CITY OF ALBUQUERQUE

December 10, 2014

**Re: Imperial Building Grading and Drainage Plan
Engineer's Stamp Date 12-8-14 (K14D106)**

GRADING AND DRAINAGE PLAN

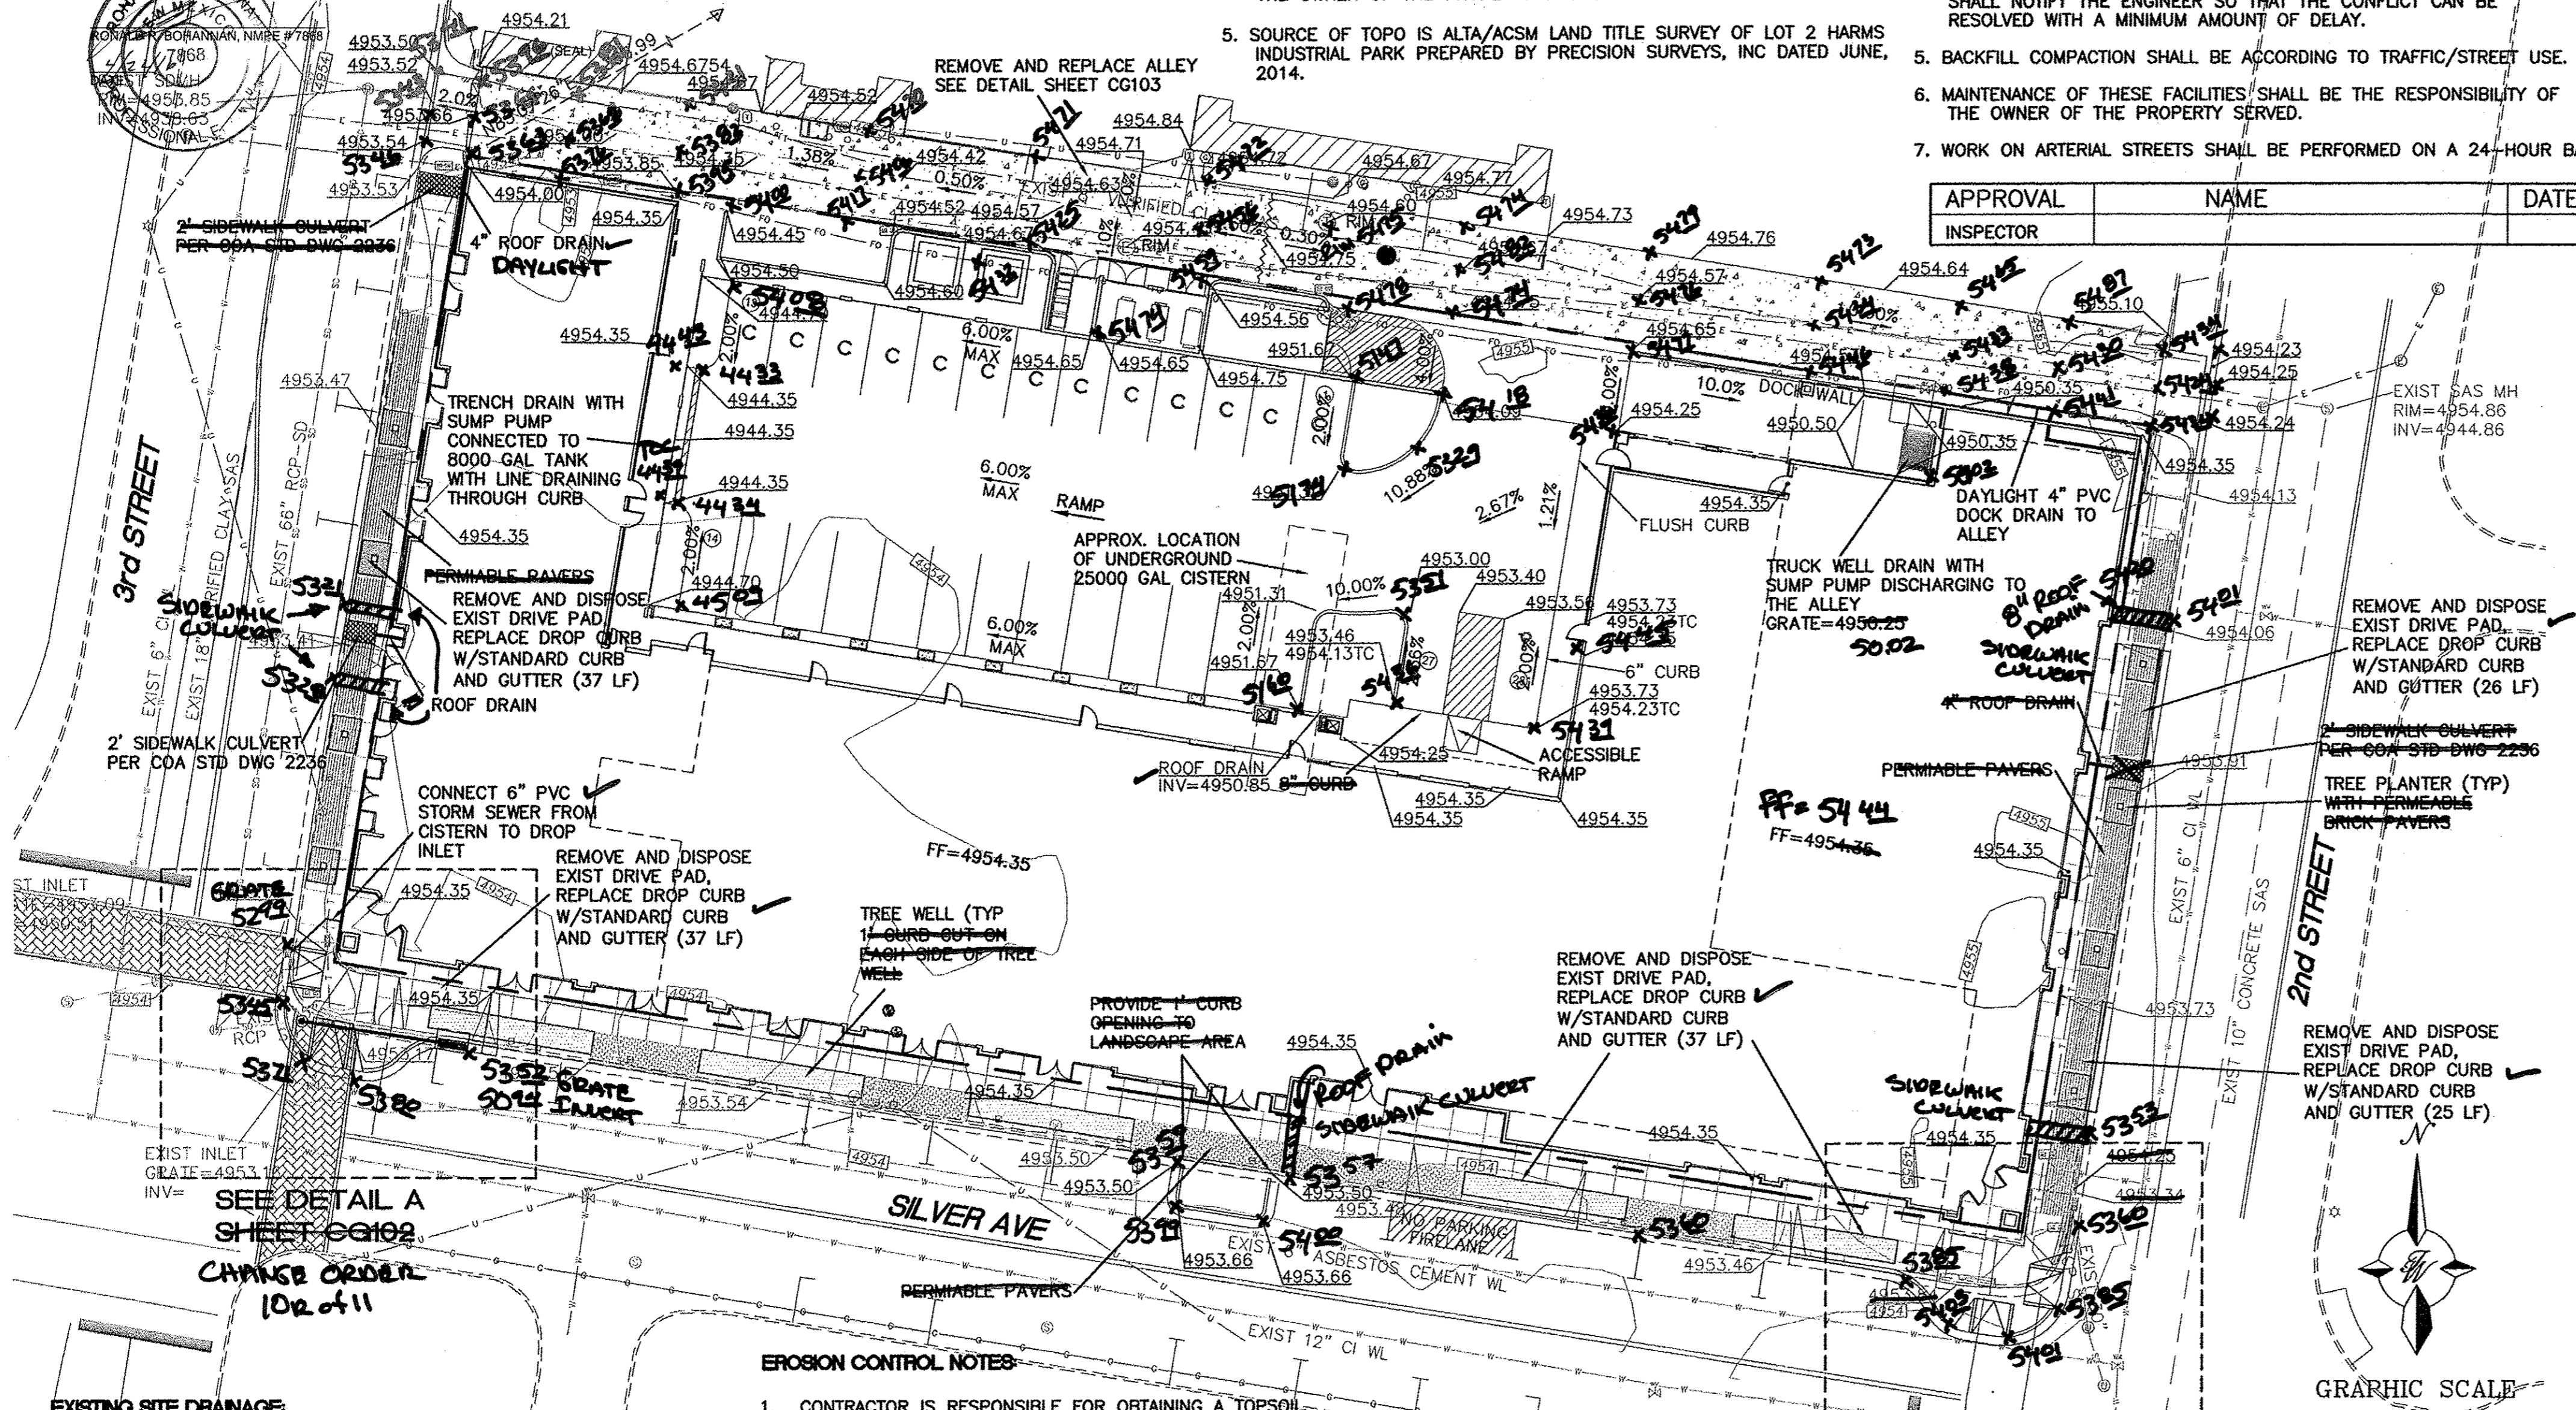
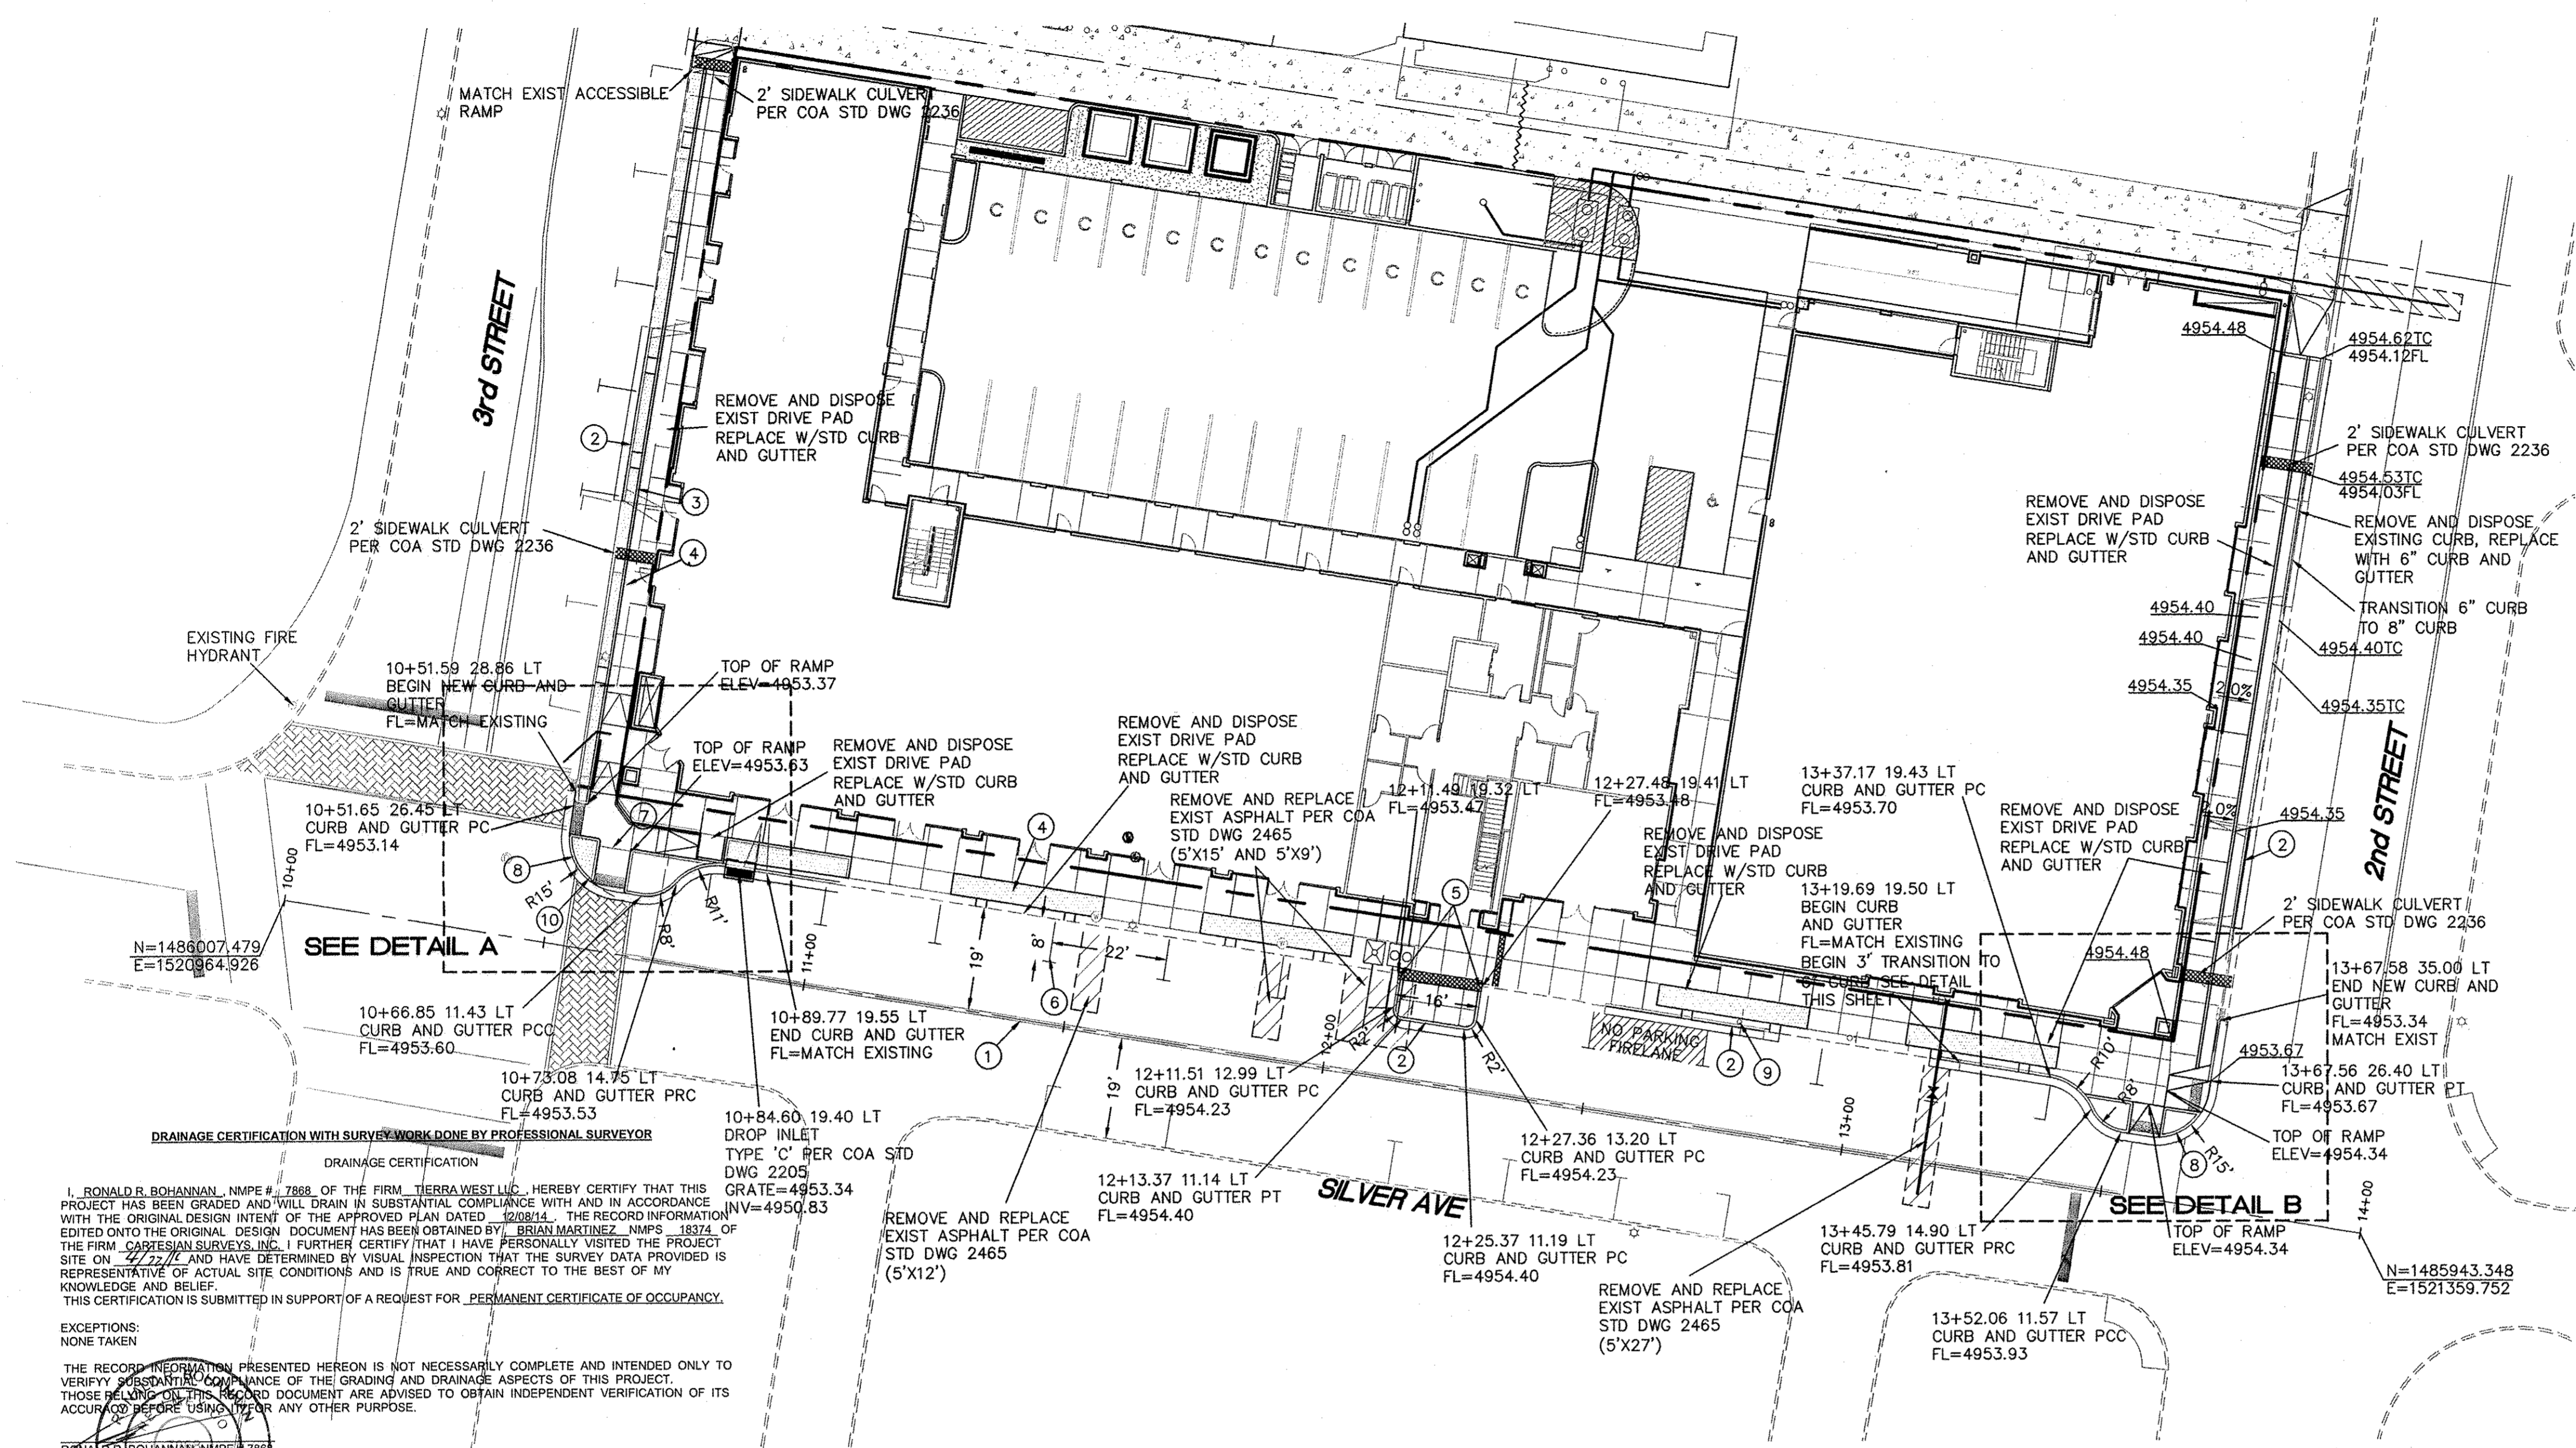
1. The 4" roof drains daylight to proposed 2' wide sidewalk culverts. Seems a 1' sidewalk culvert would work and a 1' sidewalk culvert would be preferred.
2. For brevity just include Sheets CG101 and CG102 in the Work Order for Information Only purposes.
3. SO-19 notes are included on the plan; however, all improvements in City ROW are to be constructed by Work Order.
